# City of Ryde

**Proposed Residential Development (Phase 1) and Road Construction  
on the Royal Rehabilitation Centre Sydney site at Ryde (MP10\_0189)**

**ATTACHMENT: City of Ryde submission for Phase 1 Residential for Royal Rehabilitation Centre Sydney and construction of Road 5 (MP10\_0189)**

ROAD 5 (NOPARKING)

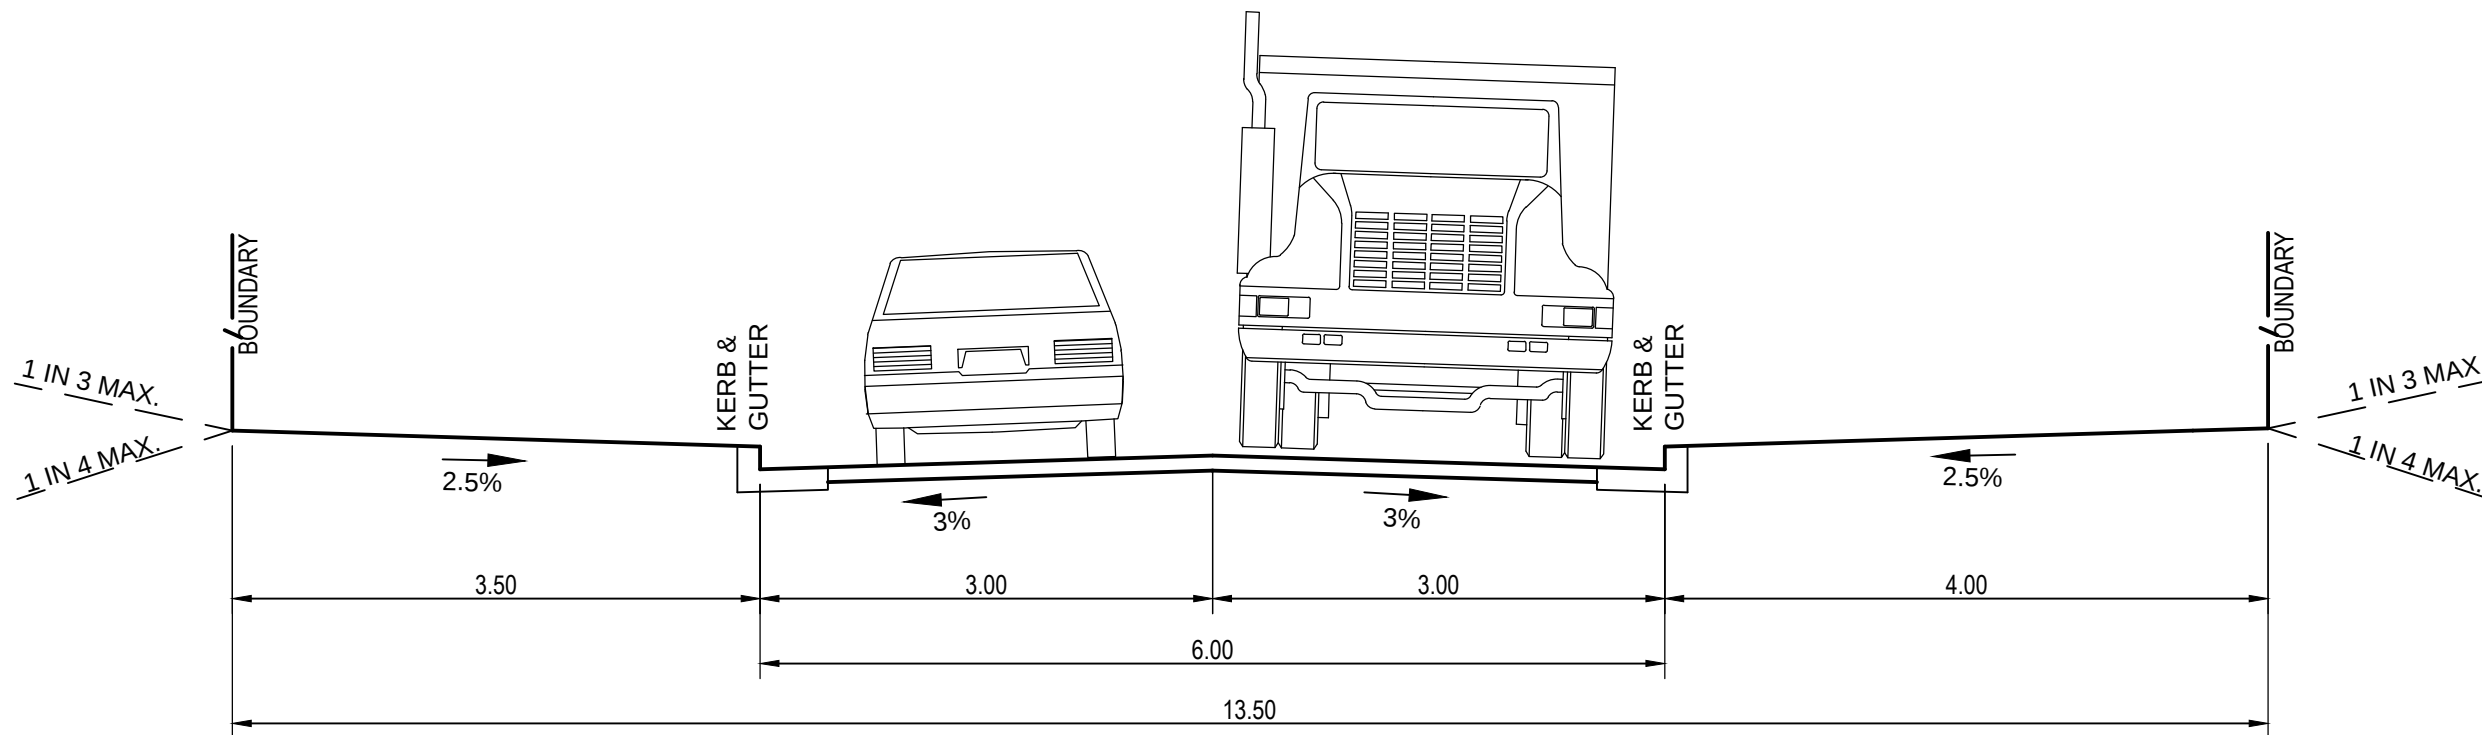
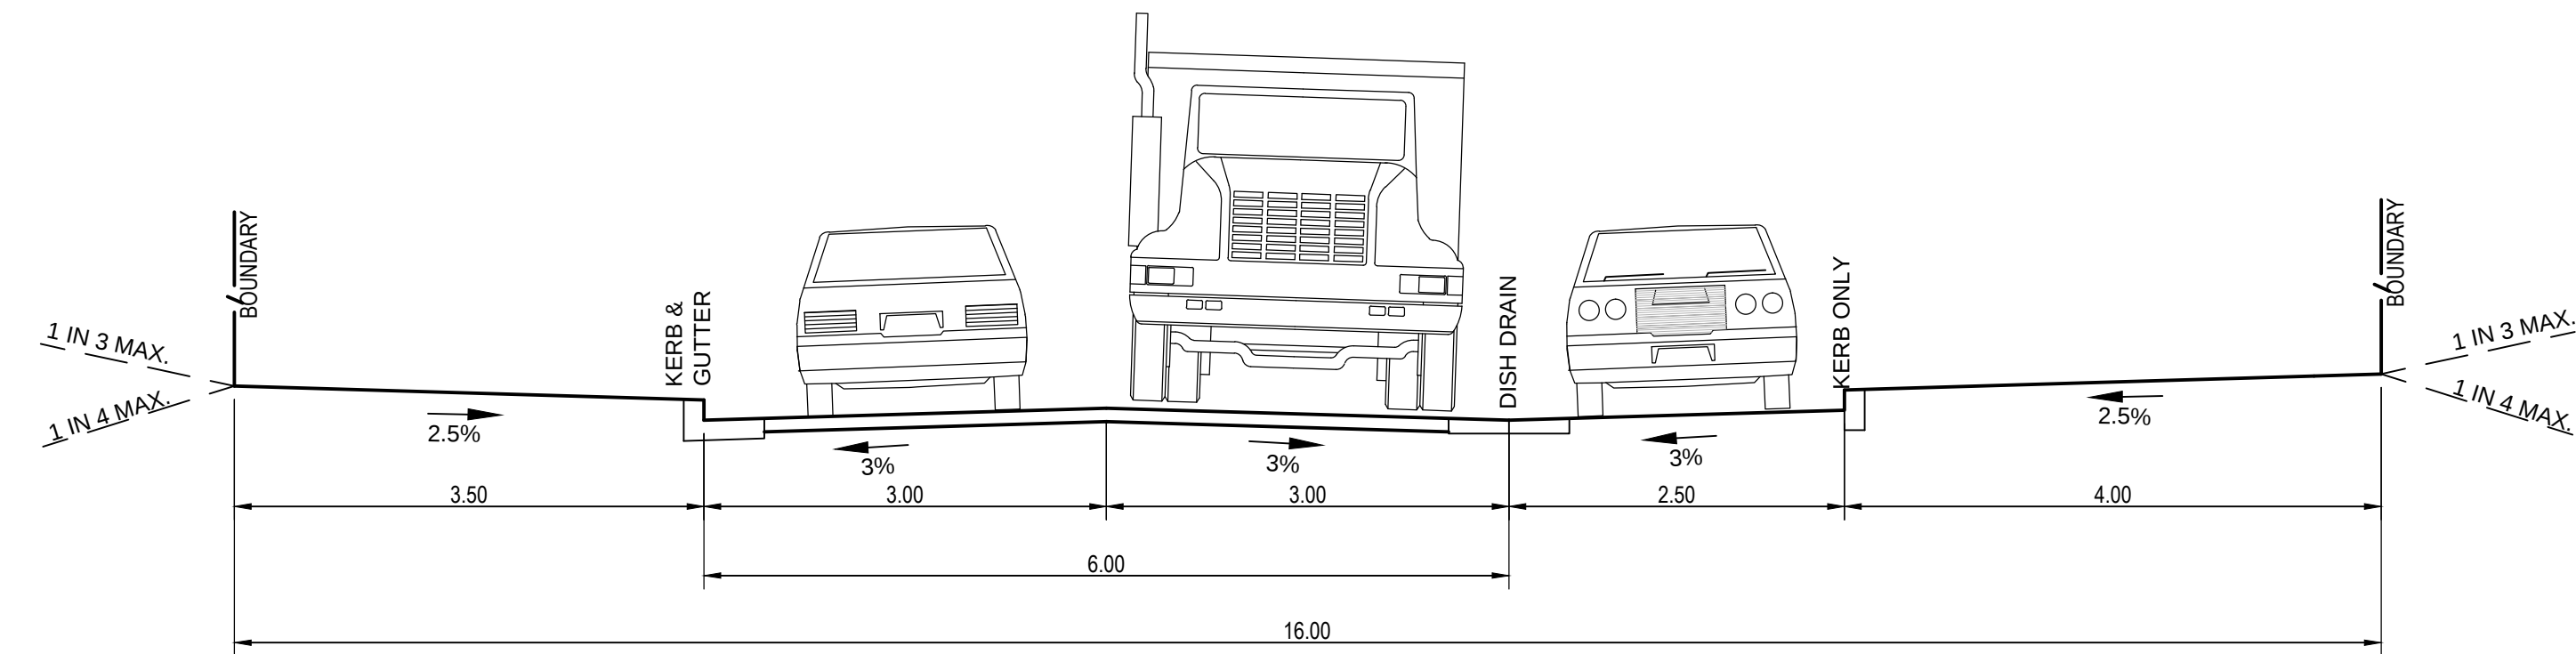
<p><b>ROAD ACCESS &amp; FRONTAGE</b></p>	<p>westward from the line approved in the Concept Plan towards the middle of the site frontage. A new slip lane is shown on Victoria Road from the eastern boundary to the realigned Road 5.</p> <p>Since the inception of this project, Council has expressed strong concern on the amount of additional traffic that will be generated by the redevelopment of the RRCS site and has supported local community concerns on the same issue. Already, the local roads around the RRCS site, and particularly Morrison Road along its southern edge, carry considerably more traffic than they are designed or constructed to carry. It is understood that Morrison Road alone currently carries up to three times more than the amount of traffic recommended under NSW Roads and Traffic Authority guidelines. The Putney community has also strongly and consistently expressed concerns about the potential safety impacts of the additional traffic on local roads affecting the local school, businesses in the shopping centre and residential properties around the RRCS site. For these reasons, encouraging access to and from Victoria Road is considered to be an essential design consideration for the site.</p> <p>Council supports the connection of Road 5 to Victoria Road. However, the Department needs to ensure that it is in the best location. The alignment of Road 5 relative to Irvine Crescent opposite should be determined having regard to possible future need for vehicular and pedestrian connections across Victoria Road in the future. The final location of the connecting road should not be allowed to create a crossing hazard for pedestrians including schoolchildren attending the nearby school. Detailed design of the intersection should be undertaken for approval by the RTA and Council as a condition of any consent.</p>

<p><b>ROADS AND OTHER INFRASTRUCTURE</b></p>	<p>Council's submission in response to MP08_0054-MOD 1 raised issues with roads and related infrastructure which is reproduced in whole below. Council is keen to ensure that the built roads can adequately function as required and that staging of construction is such that all services are provided without the need to retro-fit the road reserve and any constructed works.</p> <ul style="list-style-type: none"> <li>• A Traffic Management Access and Parking Plan is required to deal with staged construction of roads as well as final signs, line-markings and parking controls. The TMAP especially needs to address parking controls as typical cross sections are not wide enough for unregulated parking and through traffic. TMAP Plan</li> </ul>
